**City of Portland, Maine - Building or Use Permit Application**

<b>Permit No:</b> 10-1363	<b>Issue Date:</b>	<b>CBL:</b> 037 I004001
------------------------------	--------------------	----------------------------

<b>Location of Construction:</b> 480 CONGRESS ST	<b>Owner Name:</b> SCIOTO DARBY INVESTMENTS	<b>Owner Address:</b> PO BOX 18360	<b>Phone:</b>
<b>Business Name:</b> Sten House Publisher	<b>Contractor Name:</b> TBD	<b>Contractor Address:</b>	<b>Phone:</b>
<b>Lessee/Buyer's Name</b>	<b>Phone:</b>	<b>Permit Type:</b> Alterations - Commercial	<b>Zone:</b>

<b>Past Use:</b> Commercial	<b>Proposed Use:</b> Commercial - replace existing fire escape stair w/ new	<b>Permit Fee:</b> \$220.00	<b>Cost of Work:</b> \$20,000.00	<b>CEO District:</b> 1
<b>Proposed Project Description:</b> replace existing fire escape stair w/ new		<b>FIRE DEPT:</b> <input type="checkbox"/> Approved <input type="checkbox"/> Denied	<b>INSPECTION:</b> Use Group: Type:	
		Signature:	Signature:	
<b>PEDESTRIAN ACTIVITIES DISTRICT (P.A.D.)</b>				
Action: <input type="checkbox"/> Approved <input type="checkbox"/> Approved w/Conditions <input type="checkbox"/> Denied				
		Signature:	Date:

TAX MAP PLOT PLAN

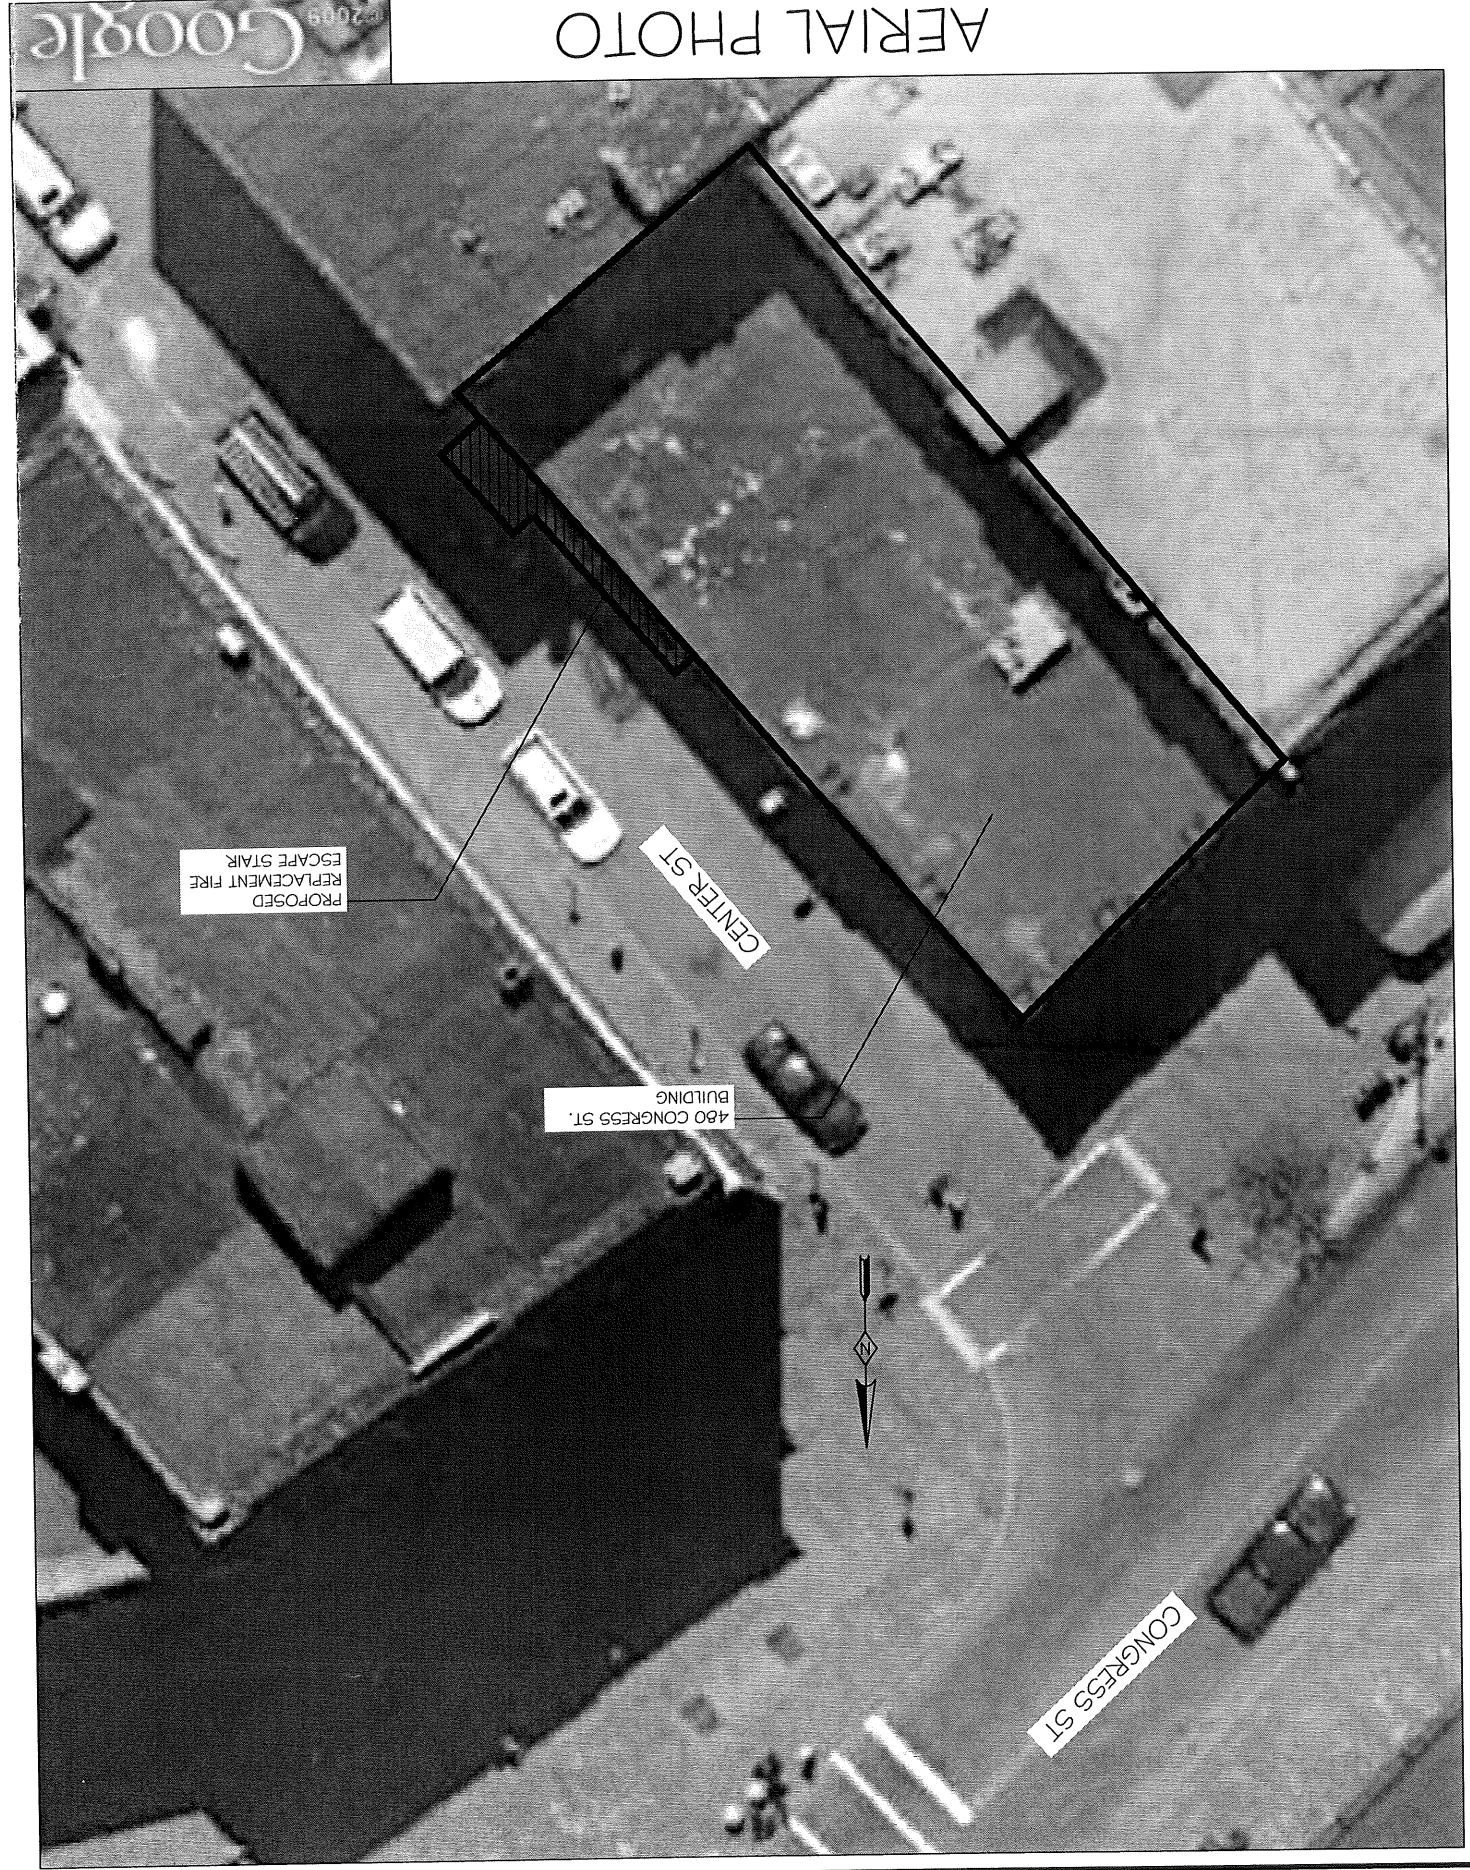
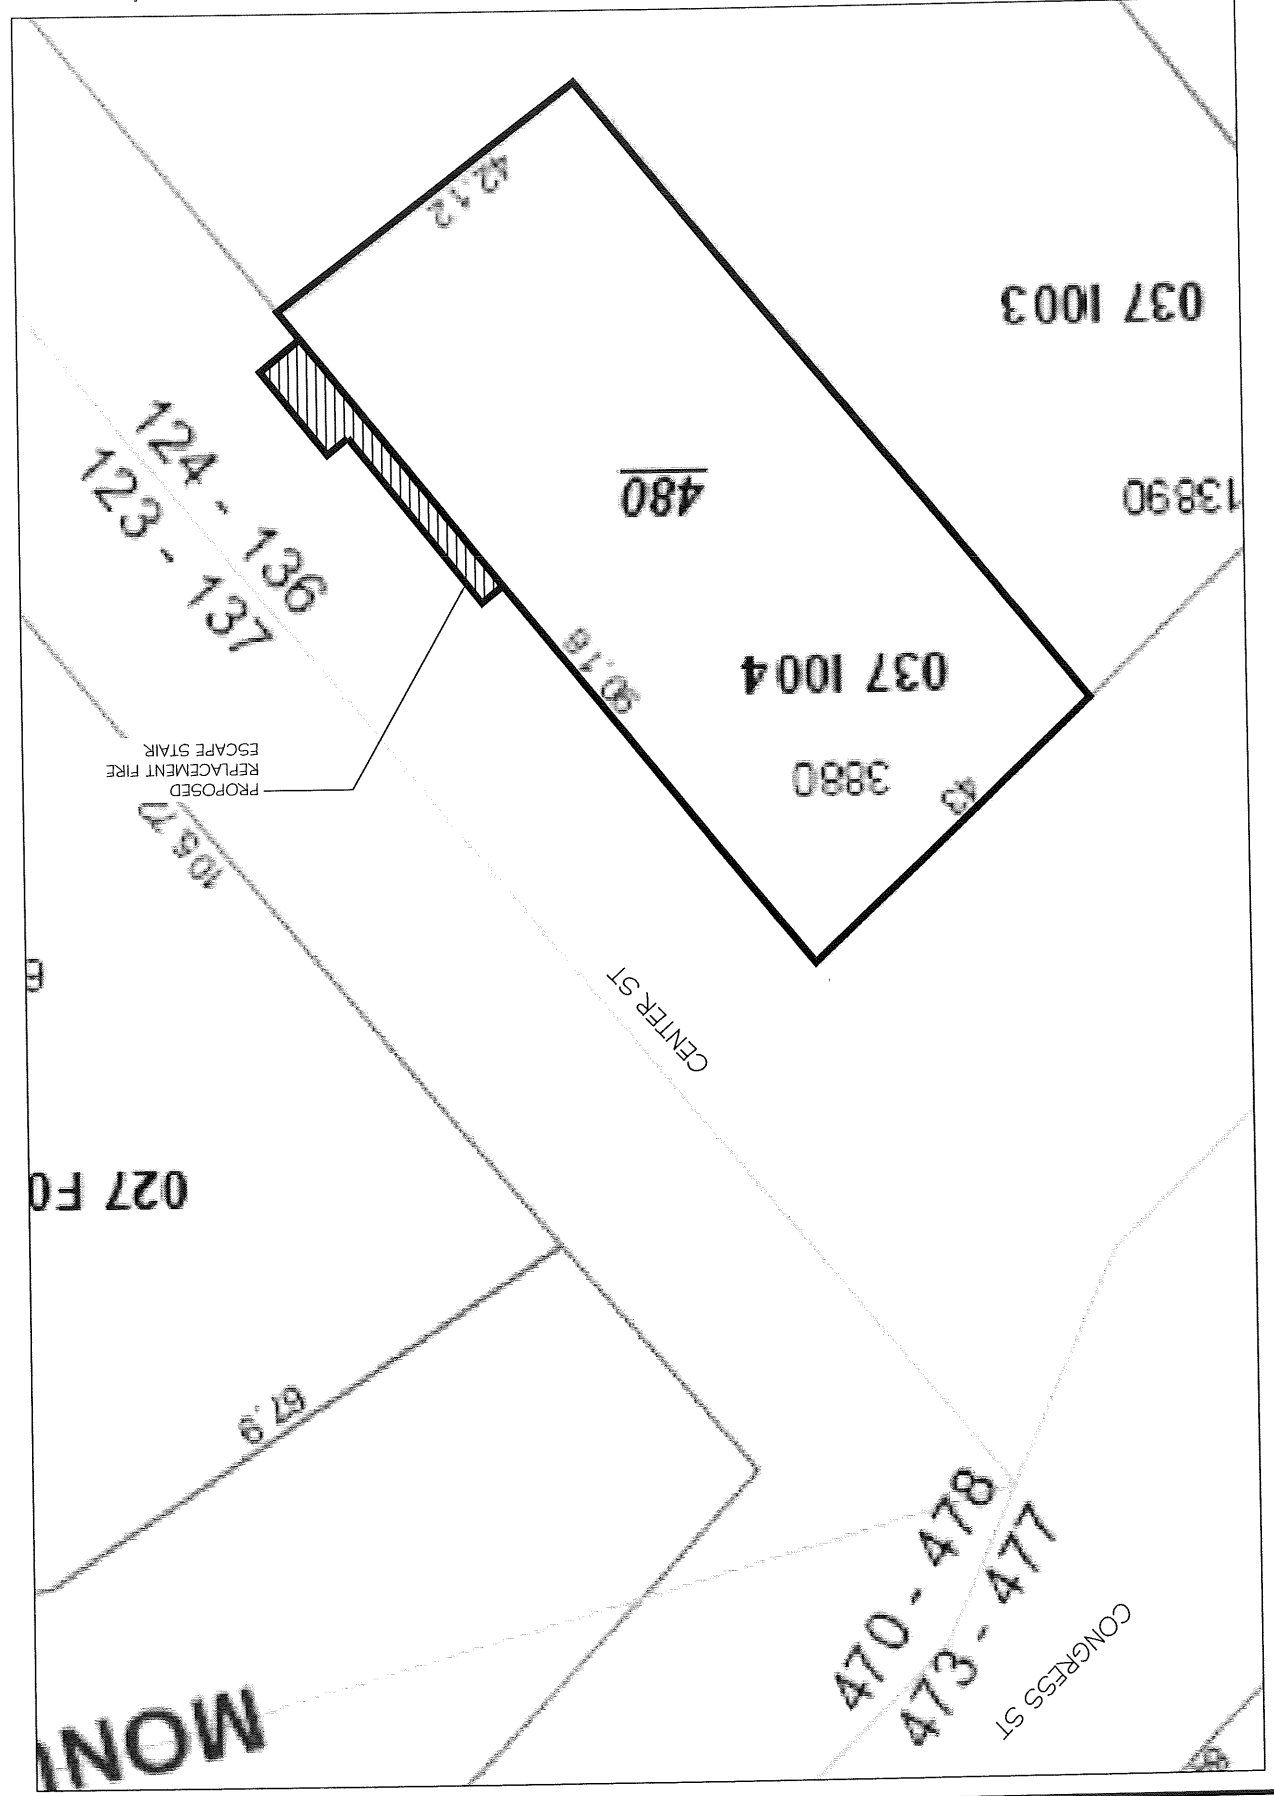
- 1) It is understood that the replacement fire escape is within the same "footprint" as the existing fire escape. Any enlargement shall require special approvals for further encroachment over City Property.
- 2) ANY exterior work requires a separate review and approval thru Historic Preservation. This property is located within an Historic District.
- 3) This permit is being approved on the basis of plans submitted. Any deviations shall require a separate approval before starting that work.

11/1/2010-mes: I called the applicant. Elaine Cyr, and left a message. No plot plan with the permit. Where is this replacement fire escape? Is it over the City sidewalk? On hold until I get info - this is also in a Historic District.

11/8/2010-mes: On 11/3/10 I received a plot plan

A2 REPLACEMENT FIRE ESCAPE STAIR  
SCALE: 3/8" = 1'-0"

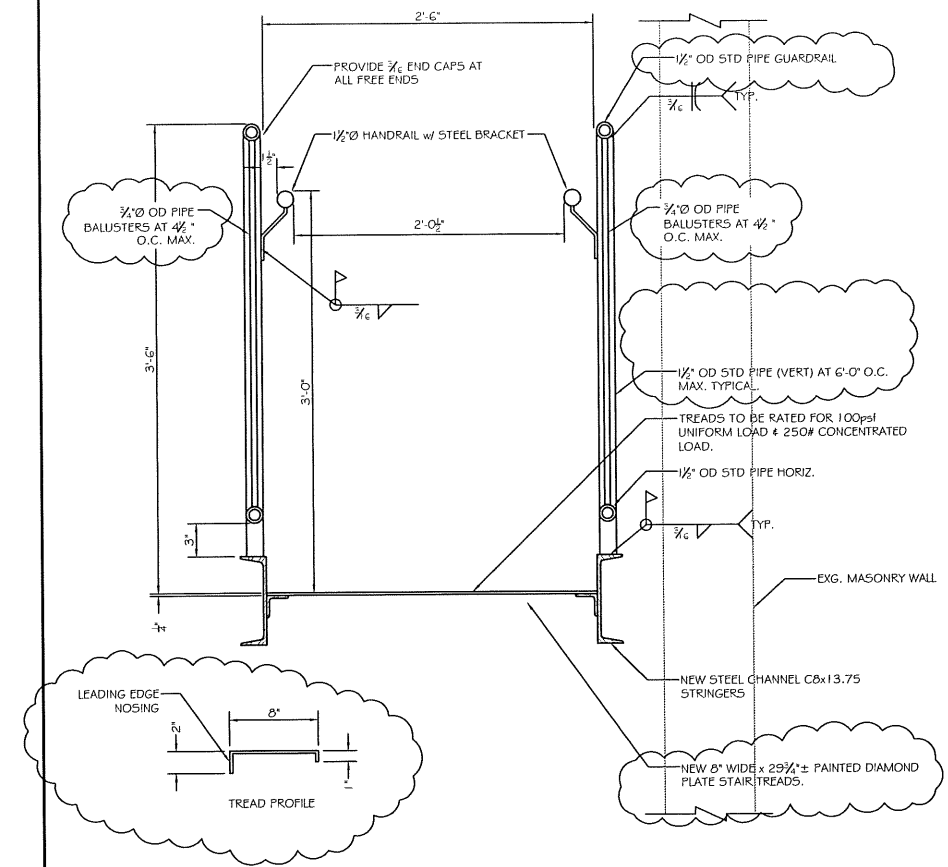
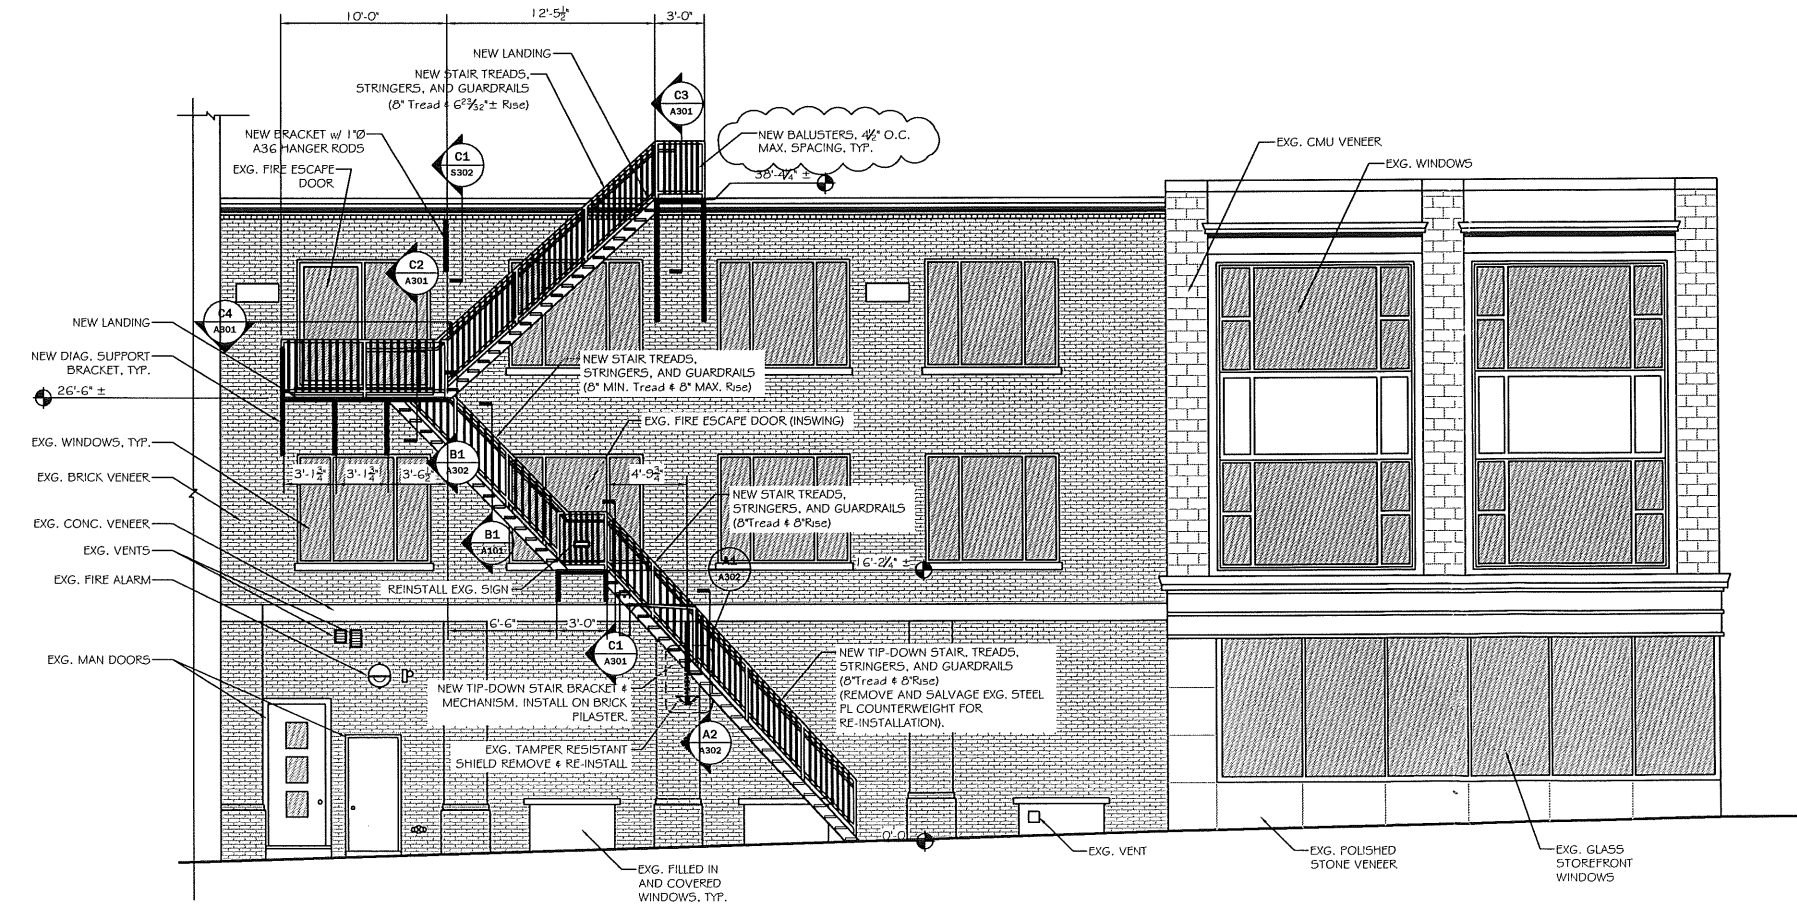
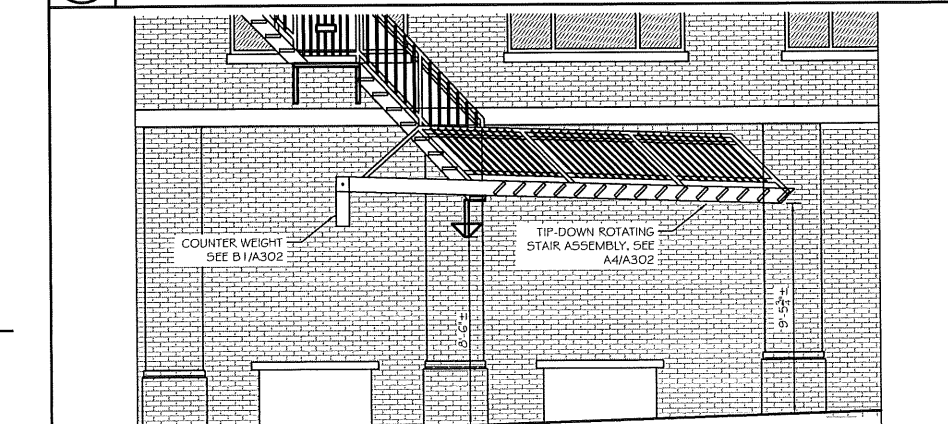
- 1) \* Entire structure to be powder coat painted (black).
  - \* HP review fee not yet paid--\$50 adm. review. Fee to be paid prior to release of building permit.
- 2) \* Entire fire escape assembly to be powder coated (black).
  - \* Historic Preservation Review fee (\$50 adm. Review fee) not yet submitted. Must be paid prior to release of permit.

**Dept:** Fire      **Status:** Approved with Conditions      **Reviewer:** Capt Keith Gautreau      **Approval Date:** 01/03/2011  
**Note:** Allowing waiver of rise/run dimensions due to existing conditions and fire glazing due to sprinklers. **Ok to Issue:**

12/17/2010-jmb: Reviewed with Keith G. For code compliance. Building and lifesafety have some discrepancies on tolerances. Spoke with Aaron W., the existing FE is 9" rise and 6" run, he was able to design the structure to meet the IBC for 8" & 8", not possible to meet 10" tread to access existing door locations. Building is sprinklered so 3/4 hr opening protection is waived. Aaron will revise plan to meet 1/2" surface opening limitation, will add handrail to make 2, and reduce guard openings to < 4". Roof access is for utilities only.

12/28/2010-jmb: Revisions submitted

1/3/2011-jmb: Reviewd revisions, ok to approve
